Reference No:	2024/62/90450/W
Site Address:	14, Lincroft Avenue, Dalton, Huddersfield, HD5 8DS
Description:	Erection of single storey side and rear extensions
Recommending Officer:	Molly Storer

HOUSEHOLDER DELEGATED REPORT

Application Number	2024/90450
Location	14, Lincroft Avenue, Dalton, Huddersfield, HD5 8DS
Proposal	Demolition of existing single storey rear extension and erection of single storey side and rear extension.
Publicity end date	29 th March 2024
Number of representations received	Two.
Kirklees Local Plan Allocation/Designation	Unallocated in the Kirklees Local Plan
Extension to Time (EoT)	Yes EoT Date: 26/04/2024
Recommendation	Conditional Full Permission

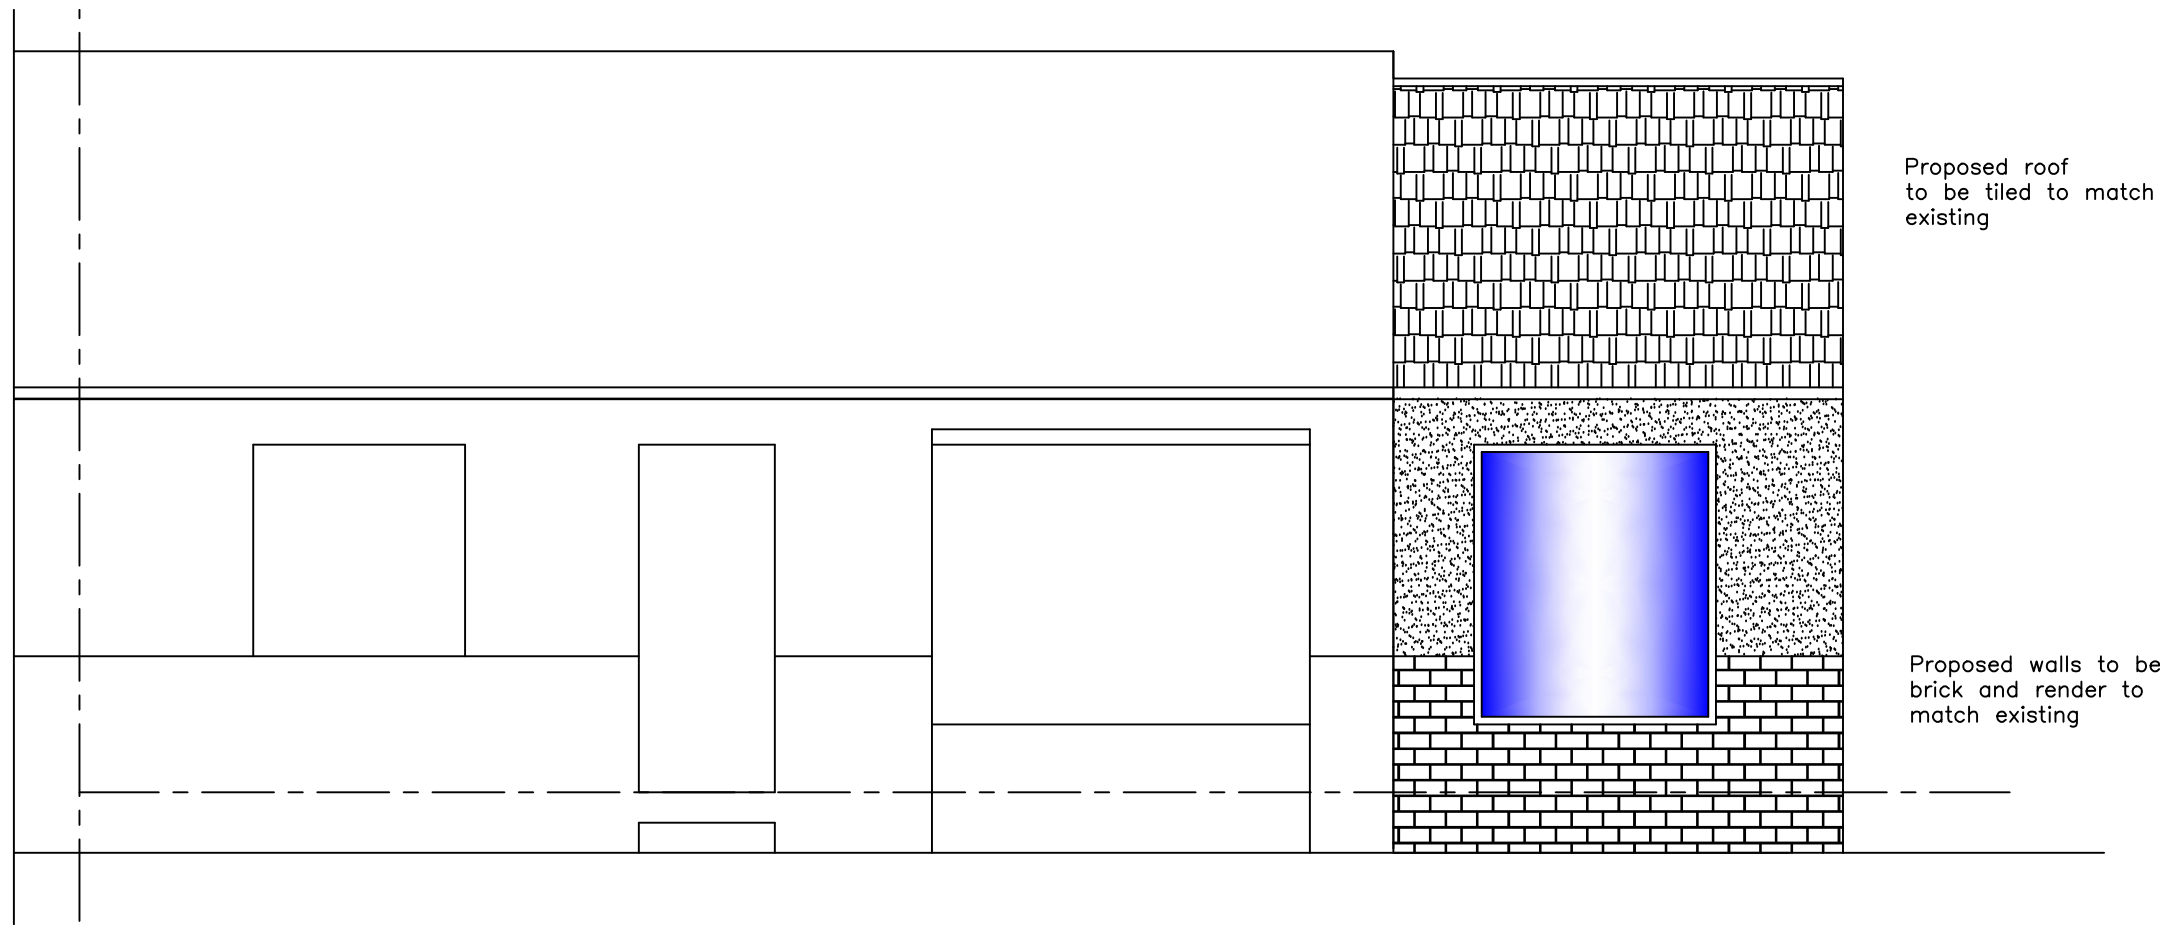
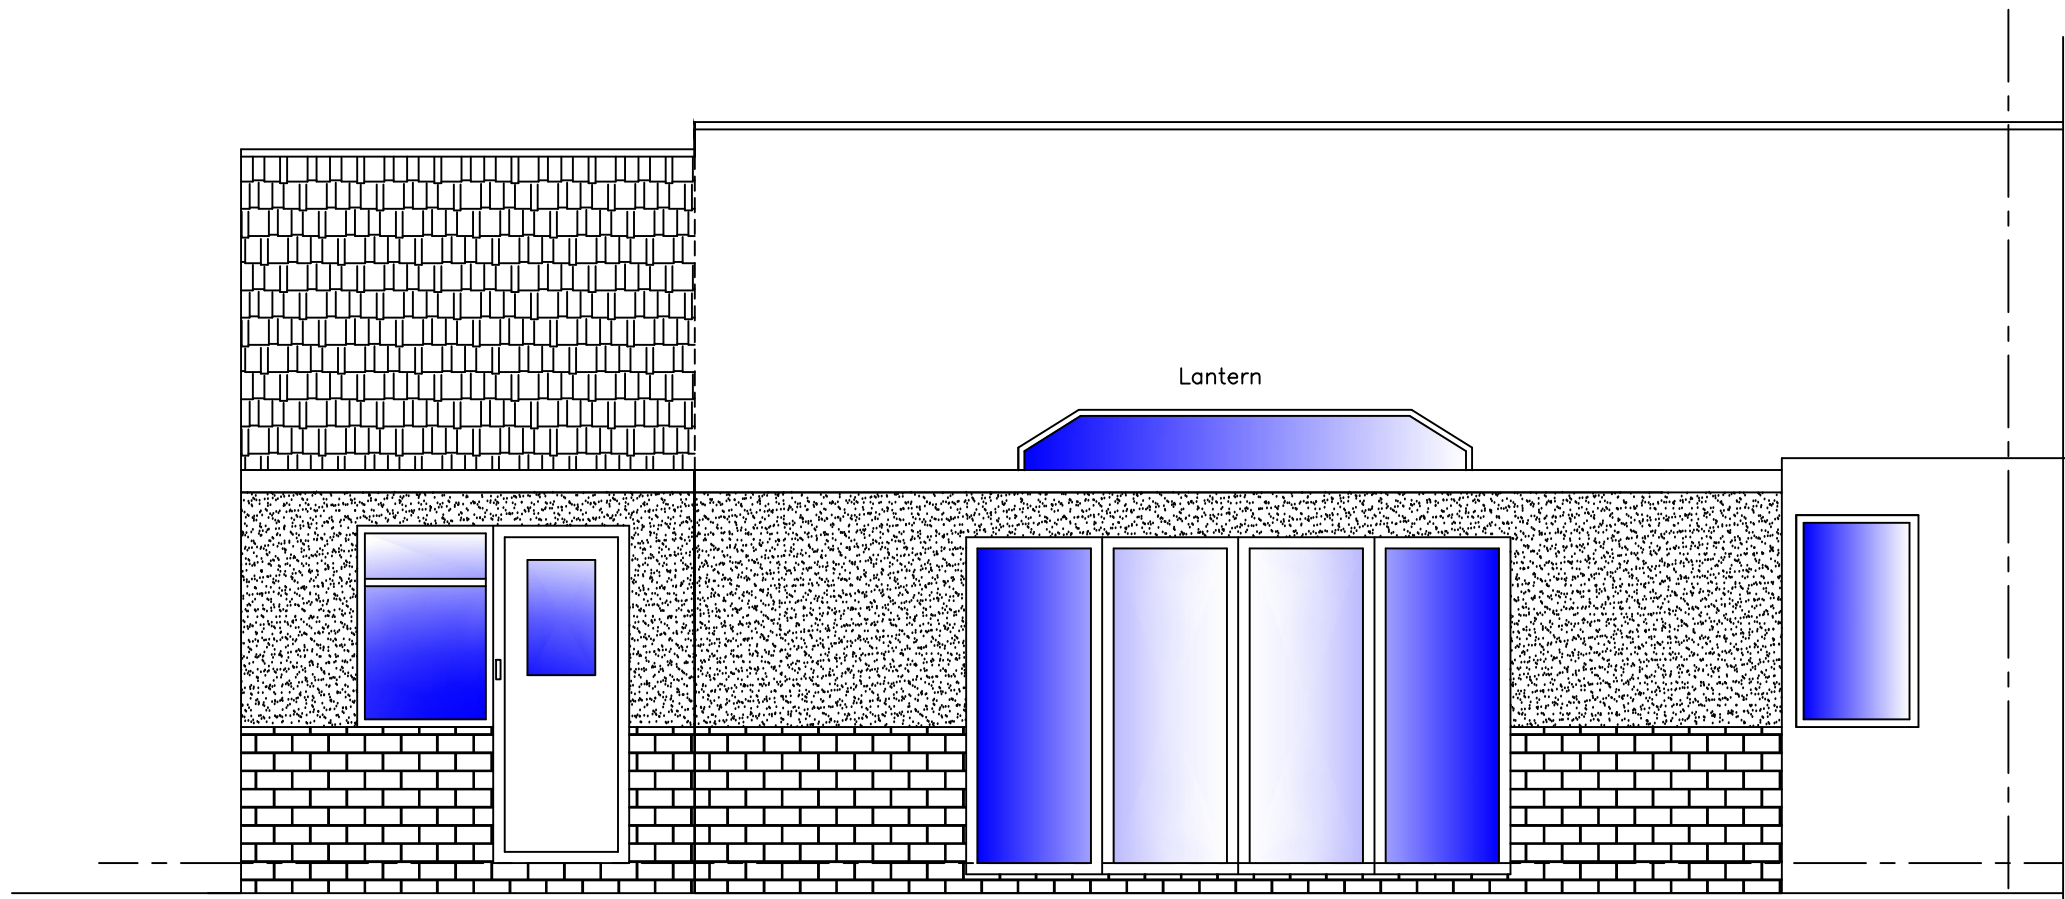
Relevant key design principle (KDP) of the SPD, Policy in the Kirklees Local Plan and the NPPF	Further comments	✓ / X / N/A
Impact on the Local character and street scene	• KDP1 of the SPD • Policy LP24 Design (a) and (c) of the KLP • Chapter 12 NPPF	The gable roof form of the side extension creates a visually harmonised effect from the outlook of Lincroft Avenue. It would have windows facing both streets and would not require changes to existing boundary treatment. In addition due to the garden surrounding the property the extensions will be somewhat set back from the road such that it is concluded to have an acceptable impact upon the street scene. Although the development would break the building line along Earles Avenue, there is already a conservatory breaking this on no. 15 and it is solely 'side elevations' fronting this road on	✓

Facing materials and detailing	• KDP 9 of the SPD • Policy LP24 Design (d) (iii) of the KLP • Chapter 12 of the NPPF	The walls are proposed to be facing brickwork with render finish and concrete roof tiles to match the existing property for the side extension. Condition recommended to ensure the materials match those of the host property.	✓
Roof style	• KDP 1 and 2 of the SPD • Policy LP24 Design (a), (c) and (d) of the KLP	Flat roof design for the rear extension to lessen any overbearing impact. Gable roof design for the side extension to match	✓

Chapter 12 of the NPPF	that of the original dwelling.	
Window proportions	- KDP 1 and 2 of the SPD - Policy LP24 Design (a), (c) and (d) of the KLP - Chapter 12 of the NPPF	There will be one large window on the front (east) elevation and side (north) there will be 3 windows. On the rear (west) elevation plans show there will be large bi folding doors to the rear extension and a single window and door on the side extension. glazing will not cause any further significant harm. There will be a roof lantern in the rear extension and no openings in the side south facing elevation.	✓
Accessibility for all users	- KDP 17 of the SPD - Policy LP24 Design (f) - Chapter 12 of the NPPF	Private domestic extension – no alterations to general access arrangement. External access to the rear of the property will remain.	✓

3. Notwithstanding the plans submitted the external walls of the extensions and roofing materials of the side extension hereby approved shall in all respects match those used in the construction of the existing building and be retained thereafter.
